Your ref:  
Our ref: 21/00094/F  
Please ask for: Miss Sandra Homcenko  
Direct dial: 01553 616824  
Direct fax: 01553 616652  
E-mail: borough.planning@west-norfolk.gov.uk

Details: **2 storey extension to side and single storey to front incorporating bedroom, utility, study and shower room. at 14 Golds Pightle Ringstead Hunstanton Norfolk PE36 5LD**

I have received a planning application as detailed above but cannot process it until I receive some more information:

Floor plans
1:50

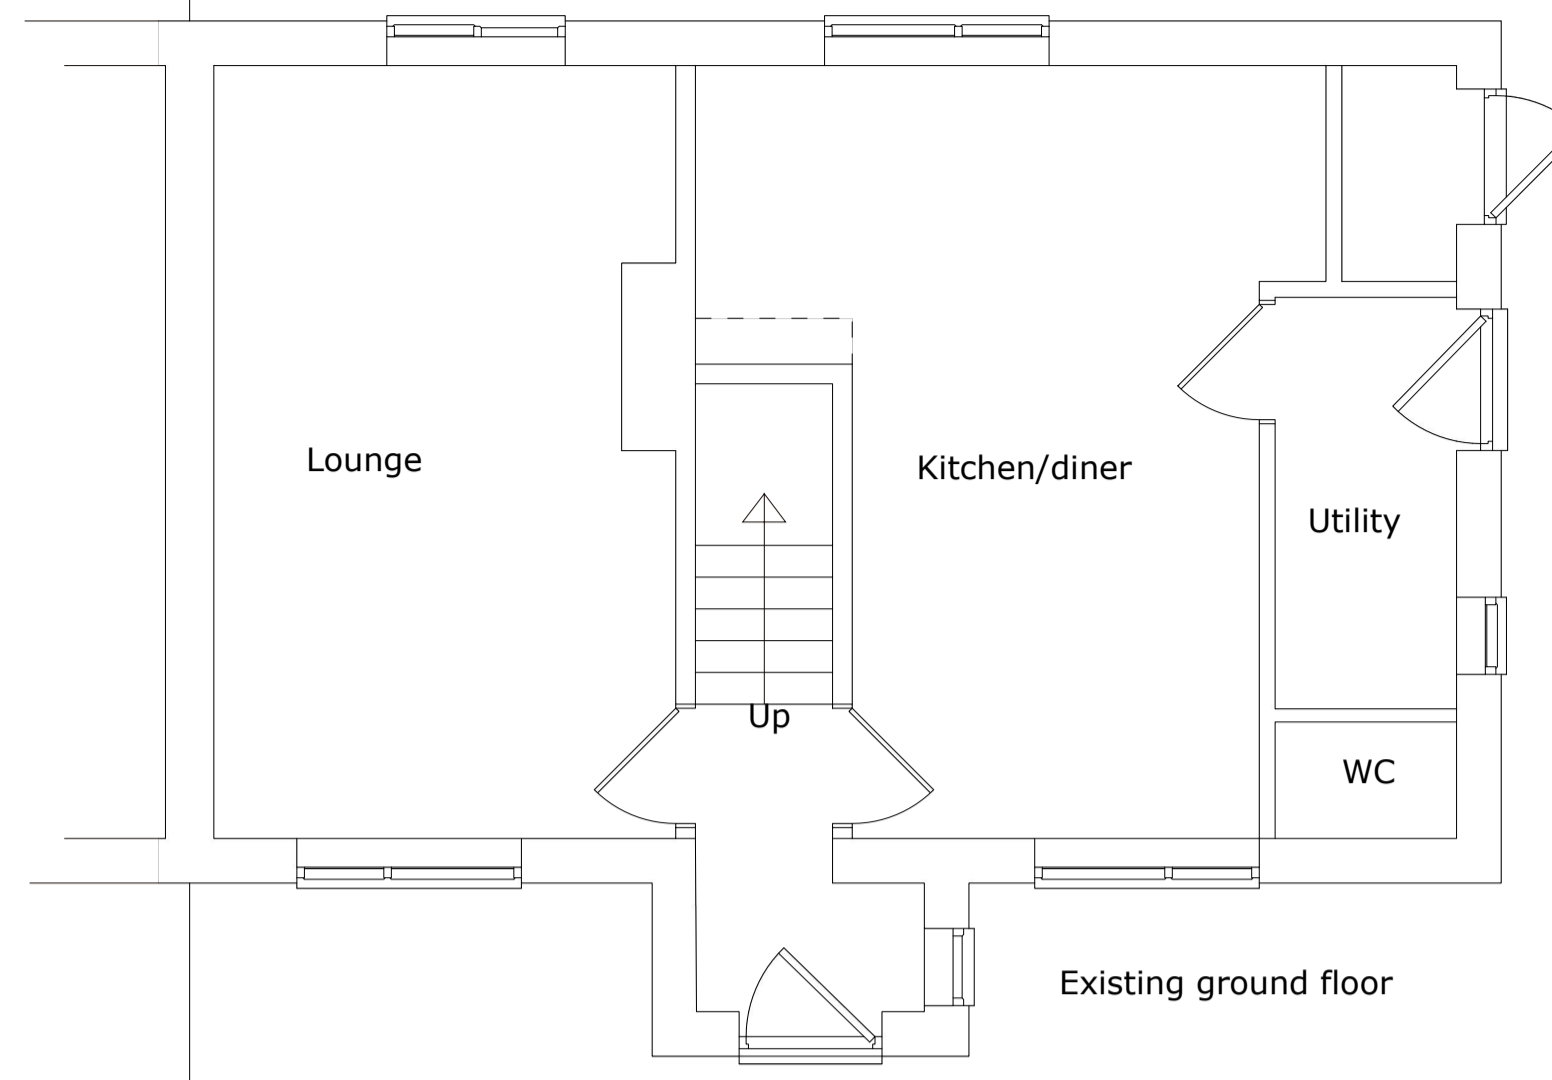
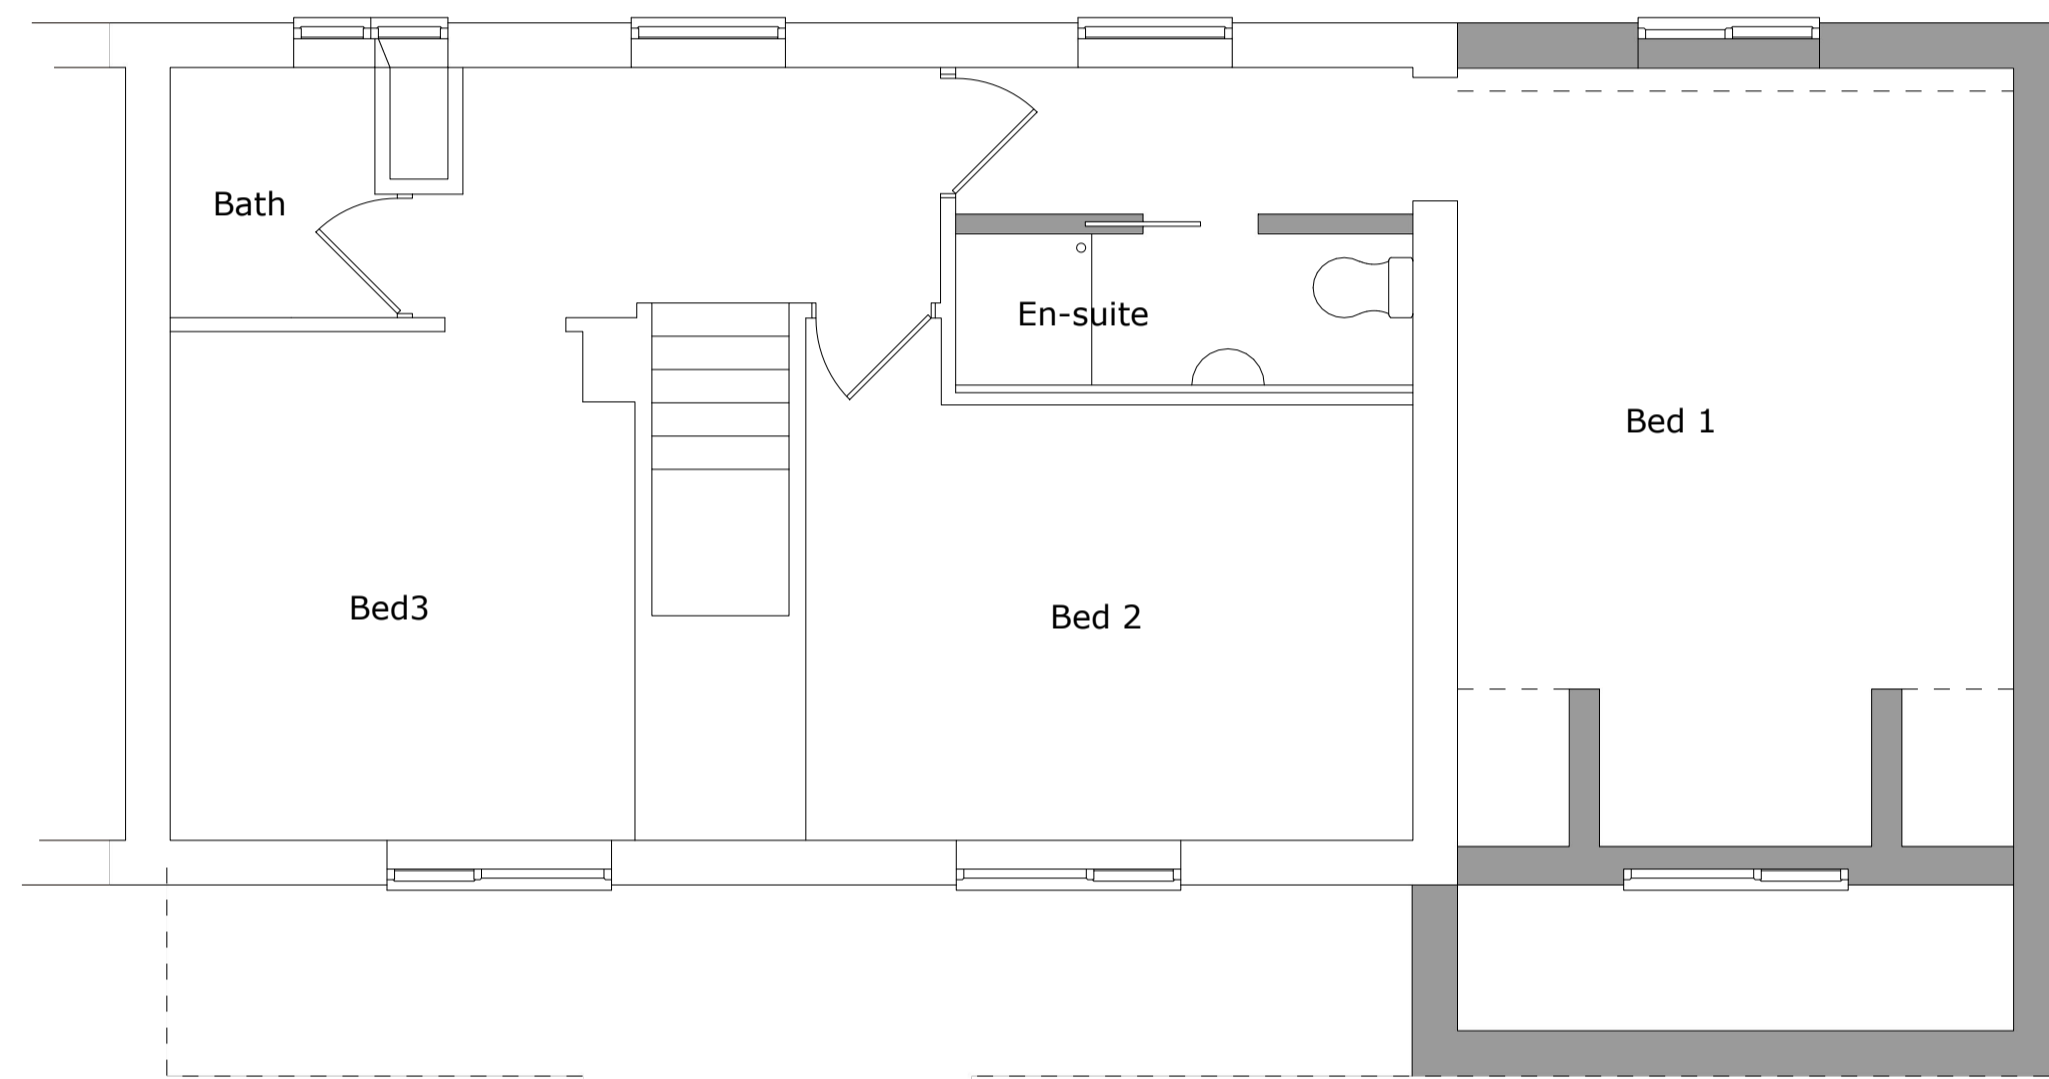
1. It appears that you submitted a car barn plans, however it is not mentioned on the proposed job description. Additionally, existing floor level plans do not match the elevations of the house, please amend this accordingly so we can validate your application.
